## Re: 31 Fore Street- finalizing the plan set/building permit process

**Subject:** 31 Fore Street- finalizing the plan set/building permit process

I understand that a building permit application has been received for the demolition of the existing building and the construction of the new 4-unit building

RIM=66.16 15"INV.IN=57.55 15"INV.IN=57.55 15"INV.OUT=57.25

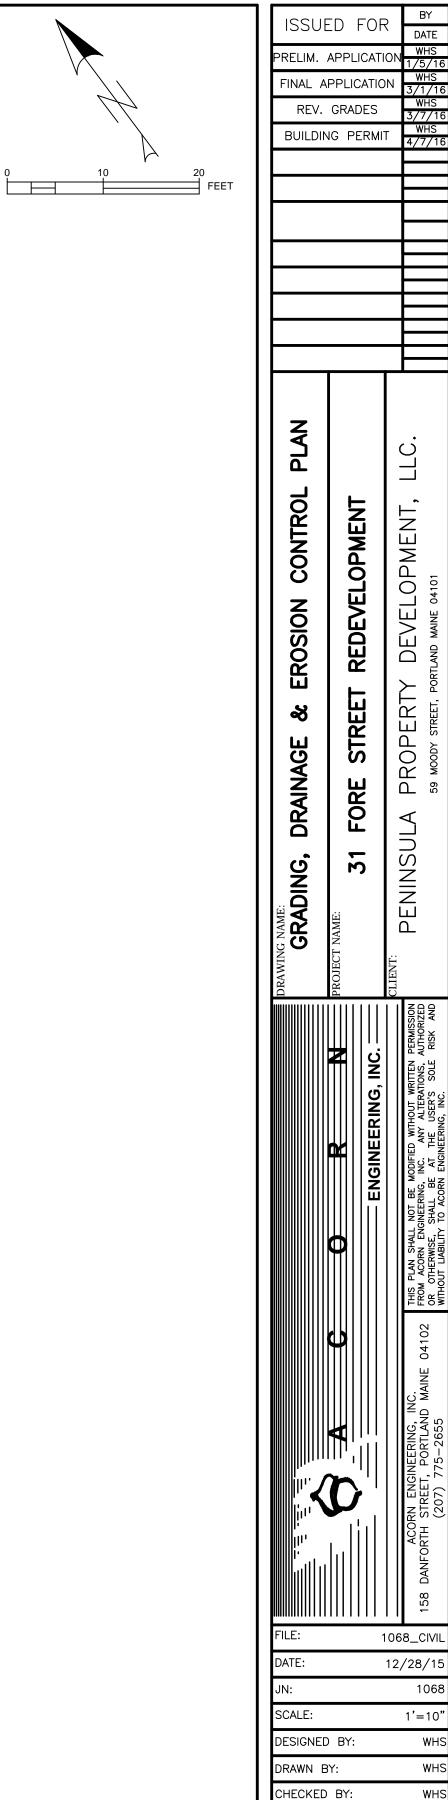
Regarding the Site Plan vii, please also show on the plan that the grade leading up to the side entrance and within the garage meets ADA requirements - since these areas have

been modified to provide ADA access to the parking space.

**As outlined in C-30 Grading and Drainage Plan, additional spot grades were added to the side entrance and internal garage further clarifying that the slope does not exceed 2% per ADA requirement.**
